Application for Removal or Variation of a Condition following Grant of Planning Permission or Listed Building Consent

Erection of a single storey rear and 2 storey side extensions, conversion of garage, replacement windows and external doors, rainwater goods and external landscaping.

21/0940/HOUS

UKSD's - Response to planning for Simon Forshaw

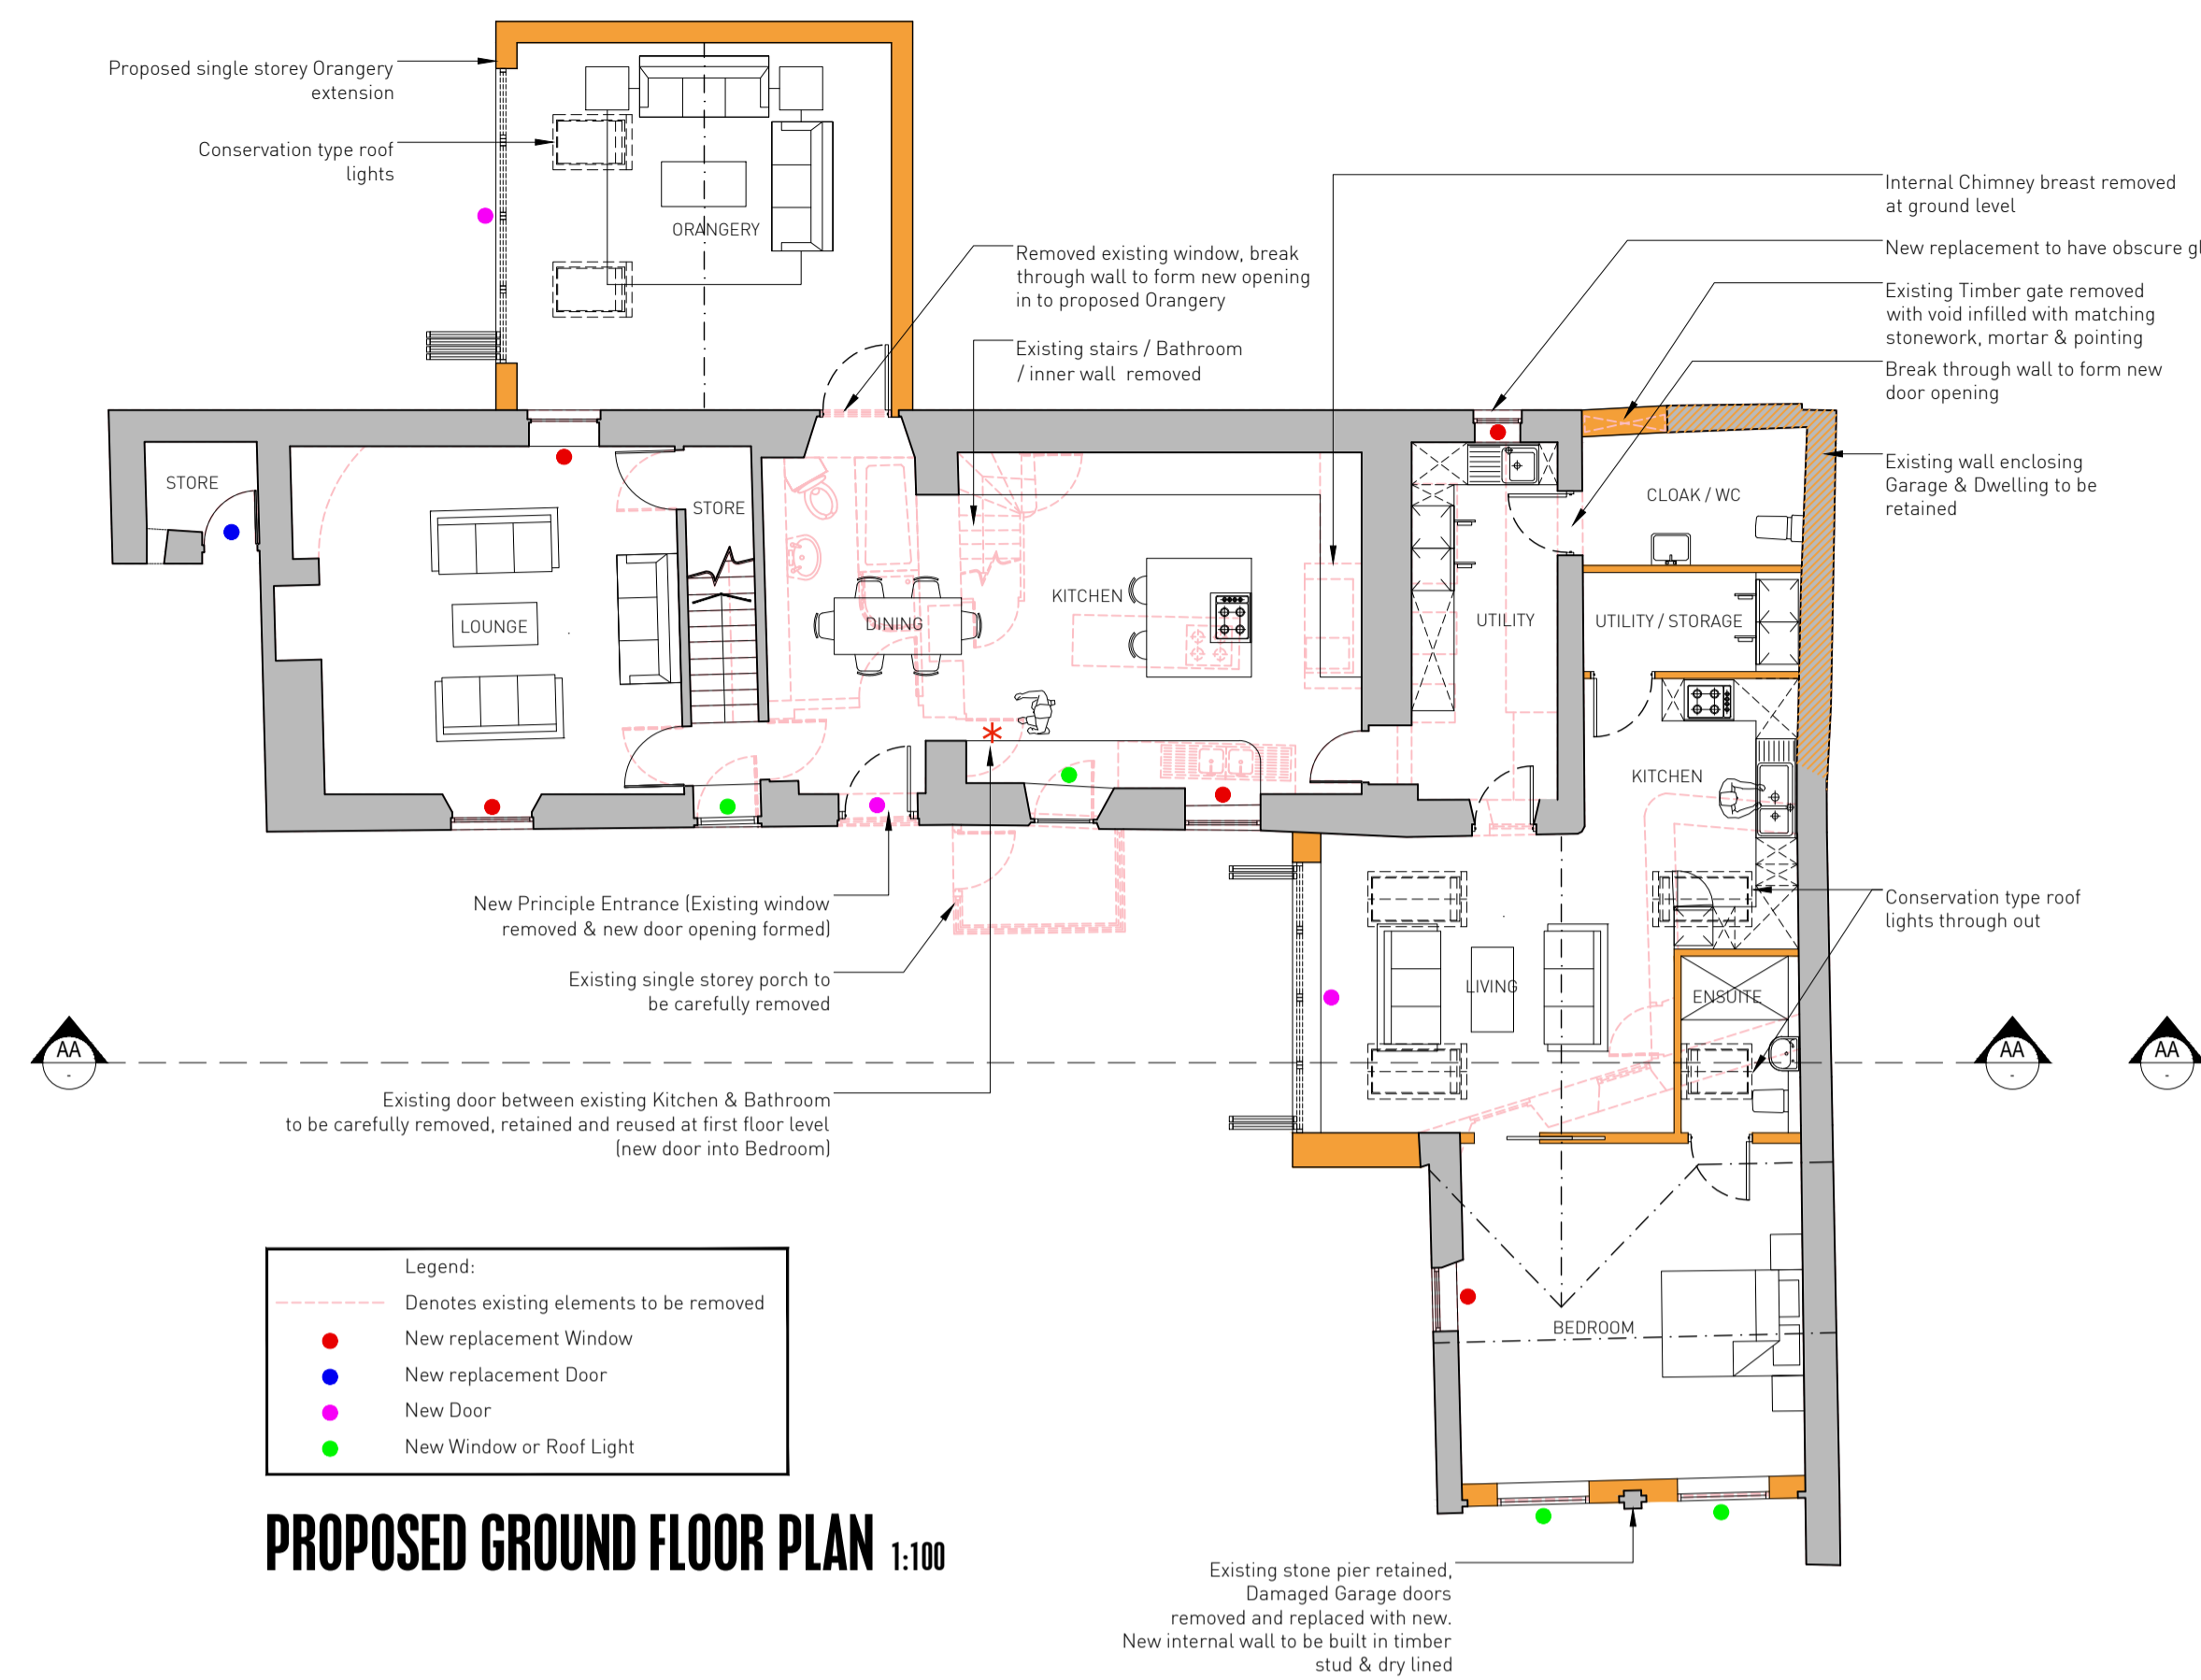
A 1st floor window on rear elevation, not shown on the approved plans, has been installed.

The faux garage doors have not been installed; instead, the apertures have been partially infilled with the intention of windows being installed in their place contrary to the approved plans. Refer to amended drawings.

The external windows and roof lights of the orangery are not in accordance with the approved plans. Drawings show 5 windows and 5 connected roof lights above. The development was found to have 4 windows and 2 separate conservation-type roof lights. Refer to amended drawings.

The roof line of the garage and front connecting single-storey extension are not in accordance with the approved plans. From inspecting the plans and consulting a resident joiner, it is clear that due to the different roof pitches, the valleys will not marry up and the plans cannot be built out correctly. This statement is supported by what has been seen as built on-site. Refer to amended drawings.

Whilst on site, I was unable to locate the sole cast iron hopper. I assume this is to be reinstalled once 'redecorated' or was obscured by scaffolding. This has not been installed yet, a temporary downpipe is in place while there is scaffolding in the way.

The window in question is indicated on the approved drawings.

A.00(a)08-03-24 PLANNING SUBMISSION		KT
Rev	Date	Description
01		MR & MRS FORSHAW
Project Title: 4 Melville Close, Branston, Lincoln, LN4 1UB		
Drawing Title: SITE & LOCATION PLANS		
Scale: 1:100 @ A1	Date: MARCH 2024	
Job No: 1689	Drawing No: UKSD-SA-08-0003	Revision No: A.00(a)

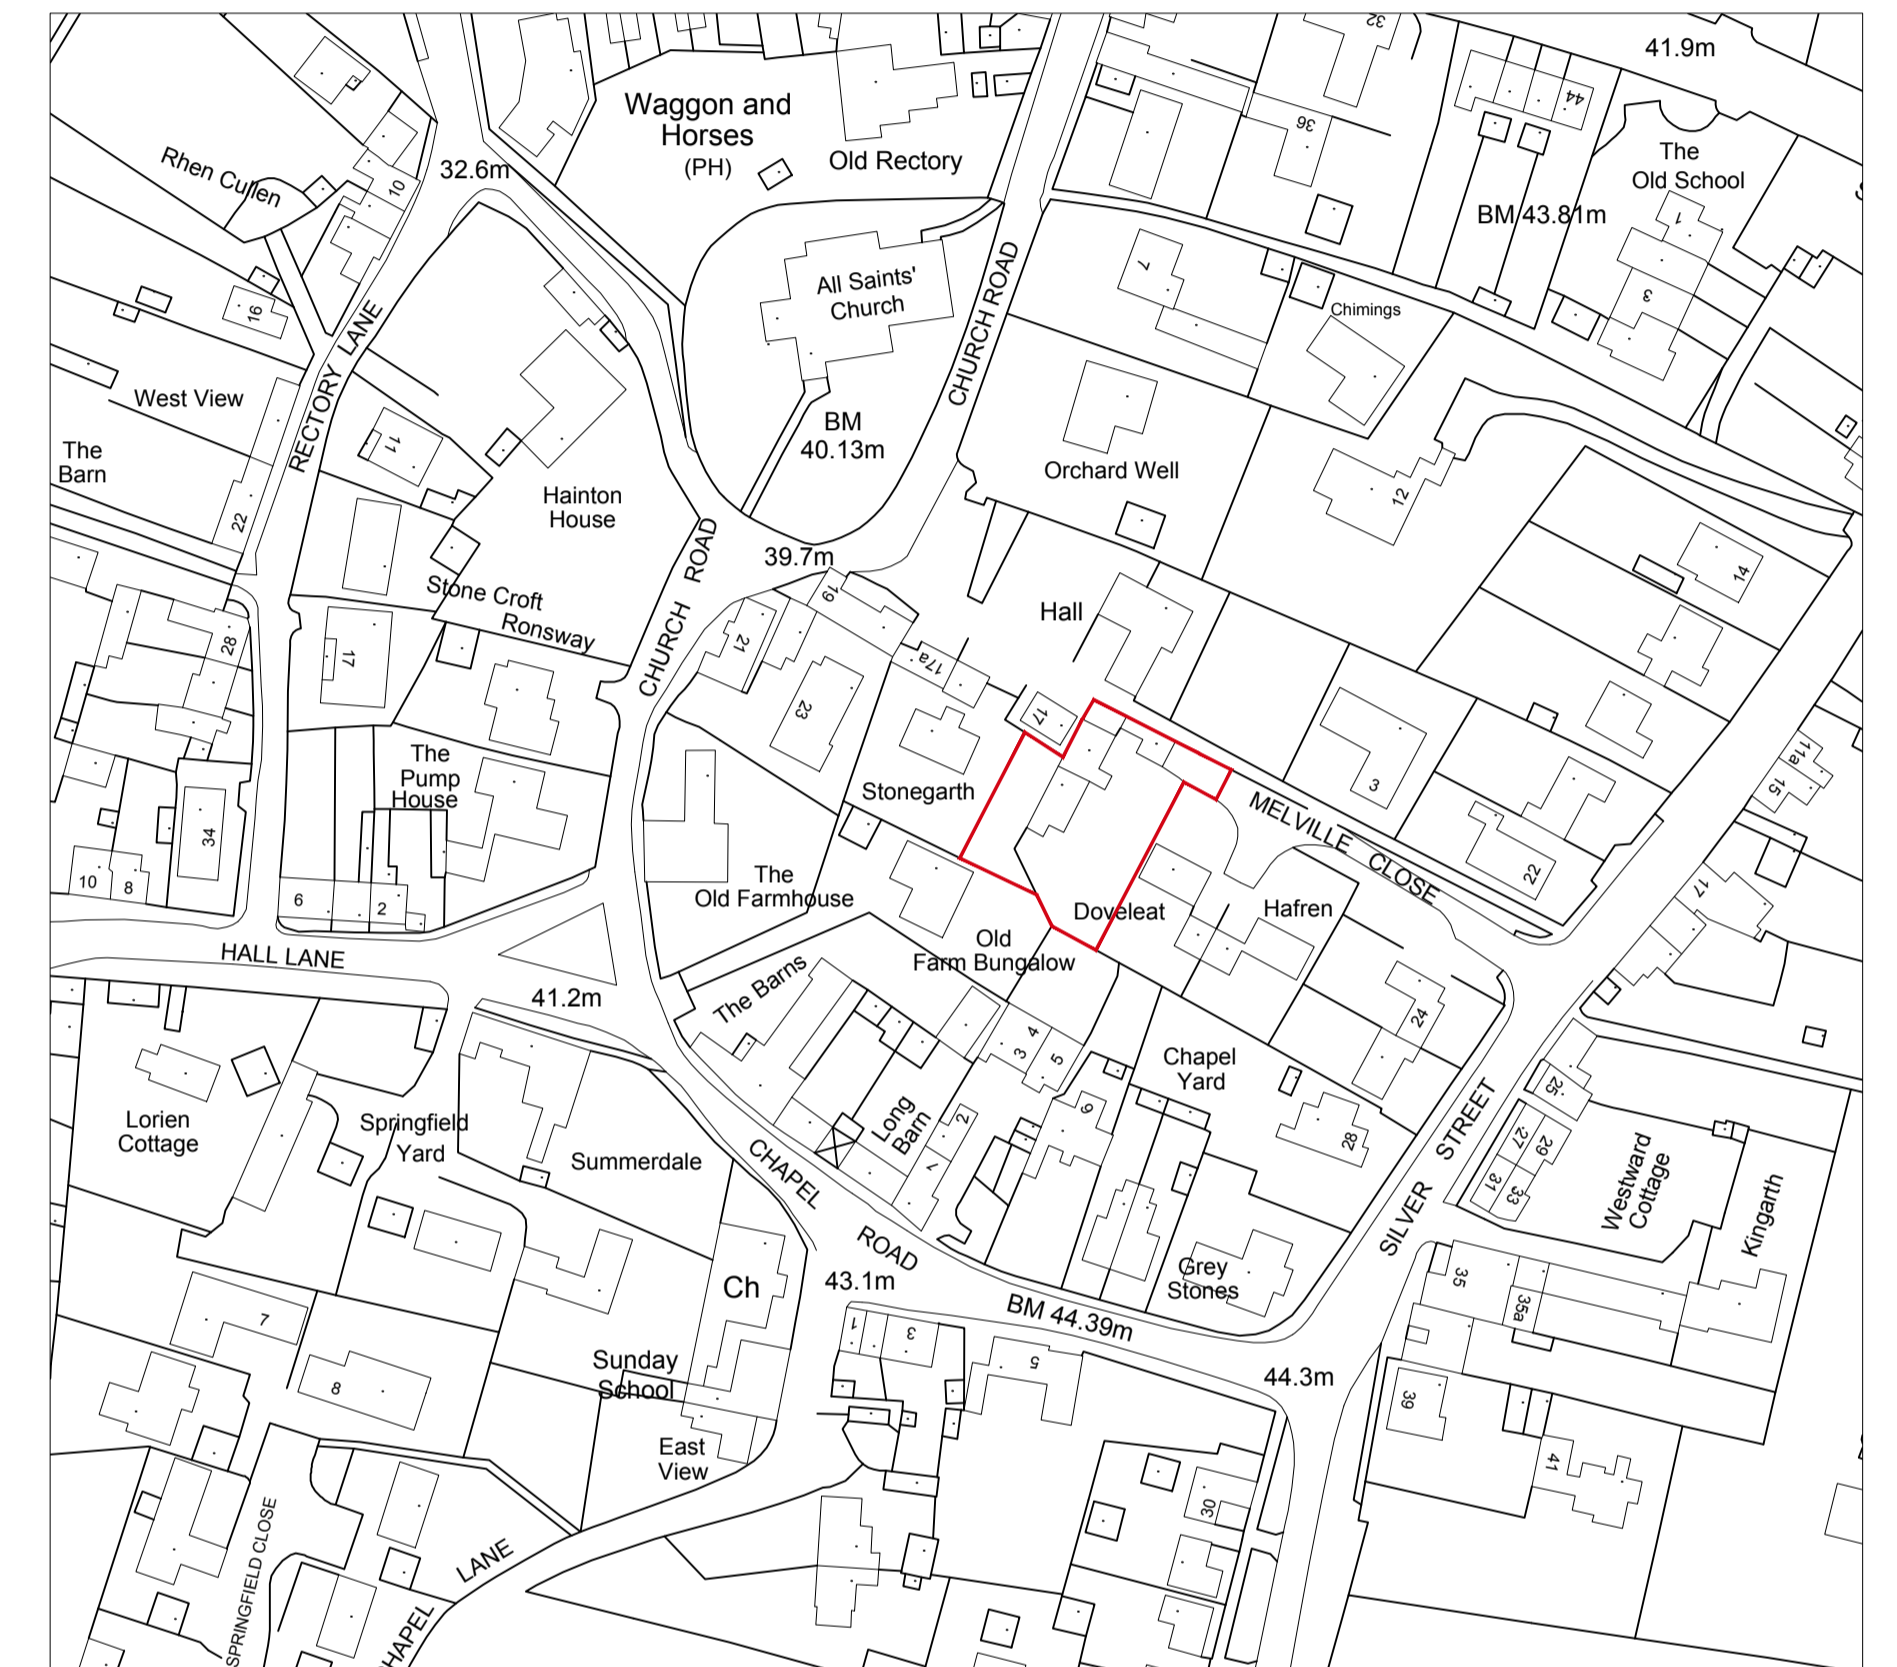
Finally, a shed has been sited at the rear of the orangery within the curtilage of the Listed Building and thus does not benefit from permitted development rights. This issue arises once more with the siting/erection of the greenhouse forward of the principal elevation and is also unauthorised. Refer to amended drawings.
